**MECKLENBURG COUNTY**  
**Land Use & Environmental Services Agency**

**MEMORANDUM**

Subject: Rezoning Petition Comments

**2023-001: Kairoi Residential**

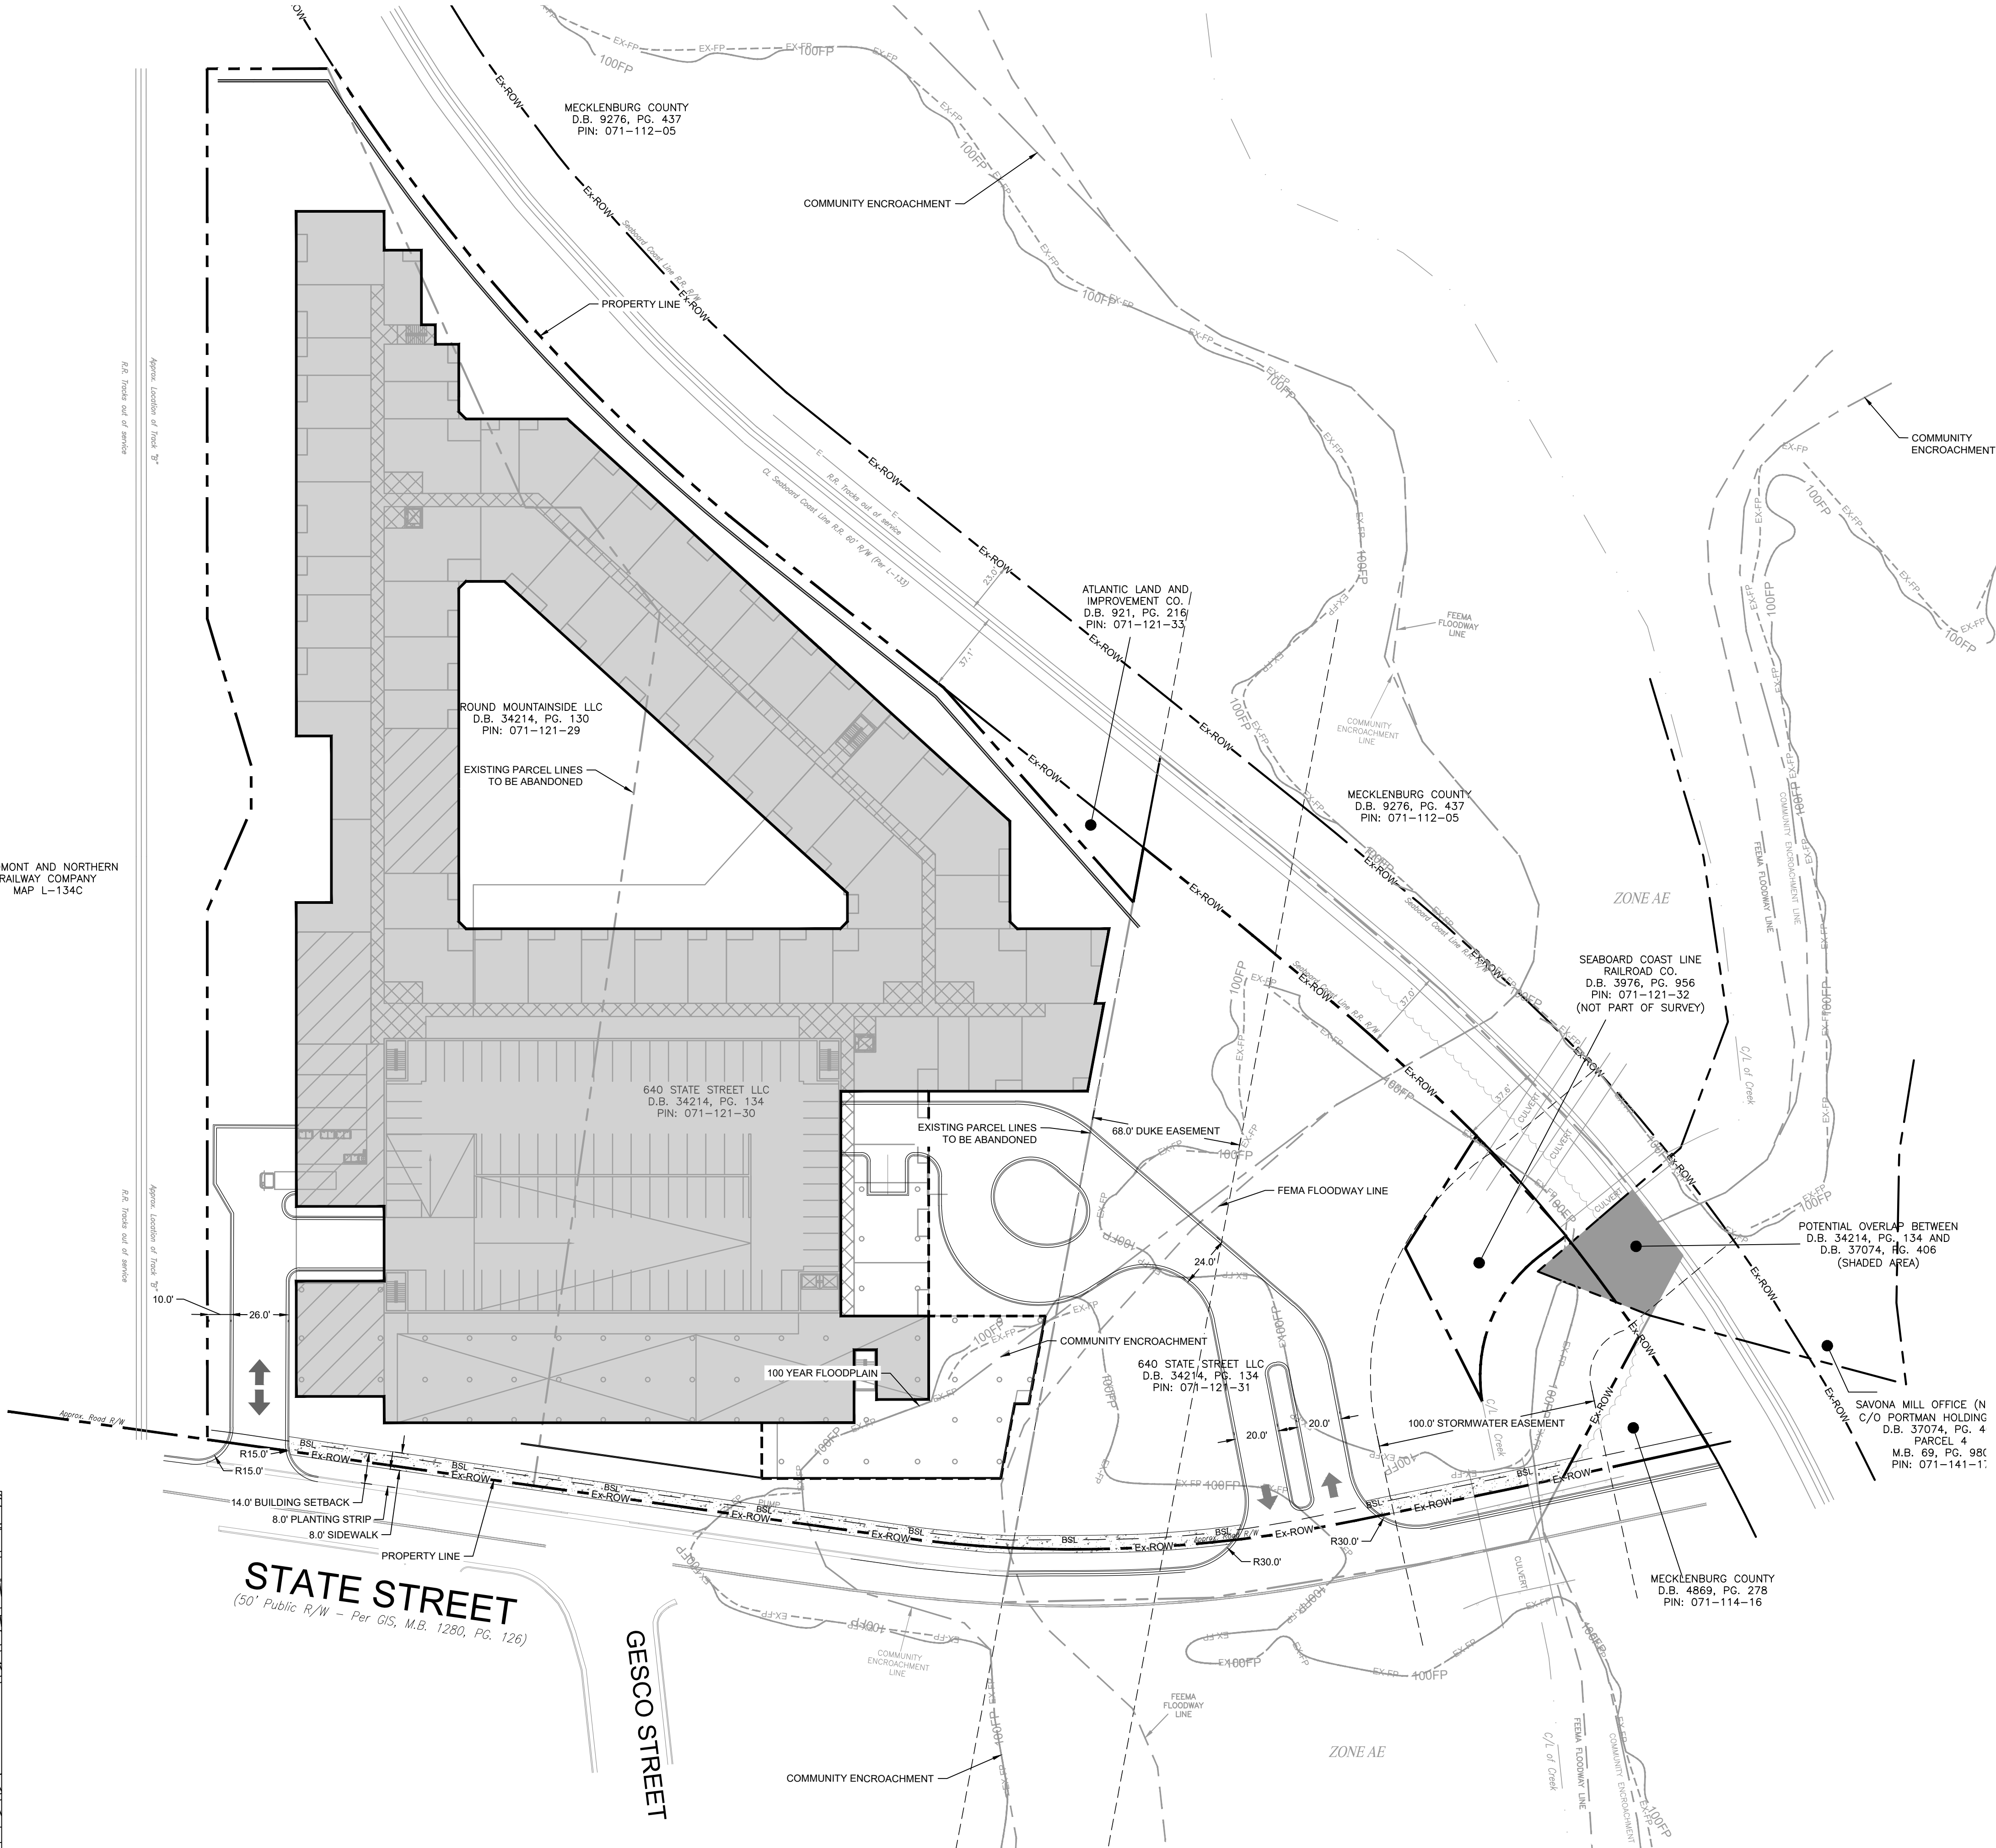
*Storm Water Services Comments:* "A Floodplain Development Permit from the City of Charlotte is required for all proposed construction within the regulated floodplain. There are specific building requirements for any proposed structure located within the regulated floodplain. See City of Charlotte Unified Development Ordinance Article 27 for details."
